**Harnett County**  
420 McKinney Pkwy  
LILLINGTON, NC 27546  
Phone:  
Fax:

**SUBJECT: BRES1903-0044**  
**BUILDING RESIDENTIAL**

Here are the results of all Inspections located at **318 LLOYD STEWART RD:**

SHT. 8

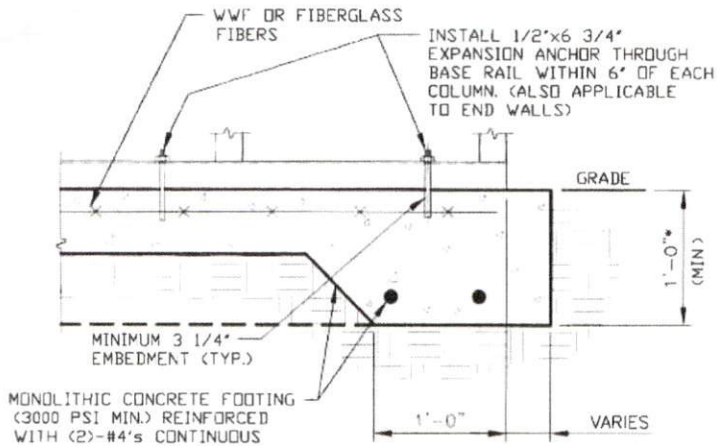
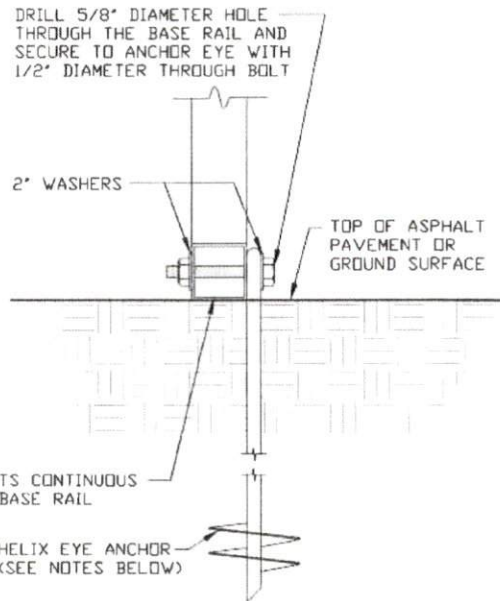
Inspection Type: ROUGH IN  
Scheduled Date/Time: 4/29/2019  
Completed Date/Time: 4/29/2019  
Inspector: Scott Guy  
Result: DISAPPROVED  
Remarks:  
Notes: 1- slab prep not ready. 2- existing concrete pad area to be used as a footer requires an engineer. 3- back fill of pad requires a compaction letter.

1- need compaction letter. 2- need engineer letter for existing slab . 3- footings must be min 12 below grade 4- all rebar connections must lap 24" and radius in corners where required.

The letter from the engineer had been emailed to MRS Gibbons on Tuesday May 5, 2019. The other issues WILL be dealt with by tomorrow morning. Thank you and I apologize.
